Principal Areas of Disagreement Summary Statement (PADSS) from National Highways Limited (“National Highways”)

Application by Gloucestershire County Council (“Applicant”) for an Order Granting Development Consent for the M5 Junction 10 Improvement Scheme (“Scheme”)

Planning Inspectorate Reference Number: TR010063

Submitted at: Deadline 5 - 01 October 2024

Figure 2-17 Plan of alternative flood storage area

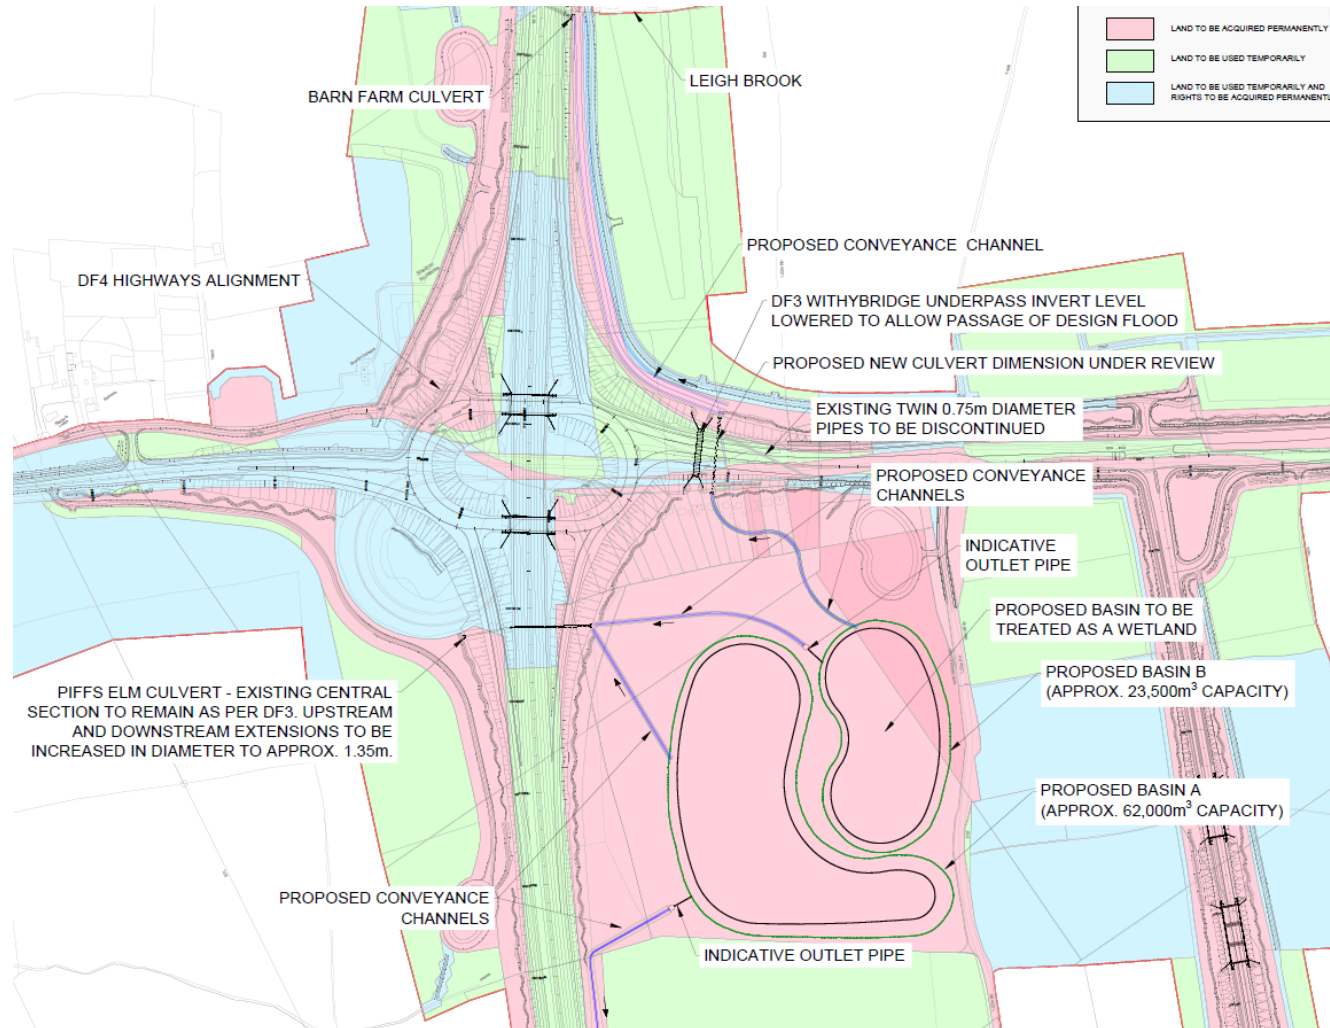
6.	Reservoir	The area of flood storage to the south-east of the new Junction 10 and the implications of the Reservoirs Act 1975 has yet to be confirmed with the Applicant. There is concern in respect of how the requirements will be incorporated into the design solution, including but not limited to the ownership, operation and maintenance of any part of the SRN that will form part of the flood storage area.	National Highways is in discussions with the Applicant in respect of the proposed reservoir. The Applicant has shared a technical note with National Highways that provides an overview of the modelling, design, operation and maintenance of the reservoir and National Highways has provided comments in response. The Applicant has responded to the comments made by National Highways and National Highways are now reviewing the further information provided. The proposals by the Applicant are not currently acceptable to National Highways. Further information and discussions, including clarity in respect of agreements with Environment Agency are required with the Applicant in respect of the principle of the reservoir as well as the practical implications of operation, maintenance and ownership.	Low
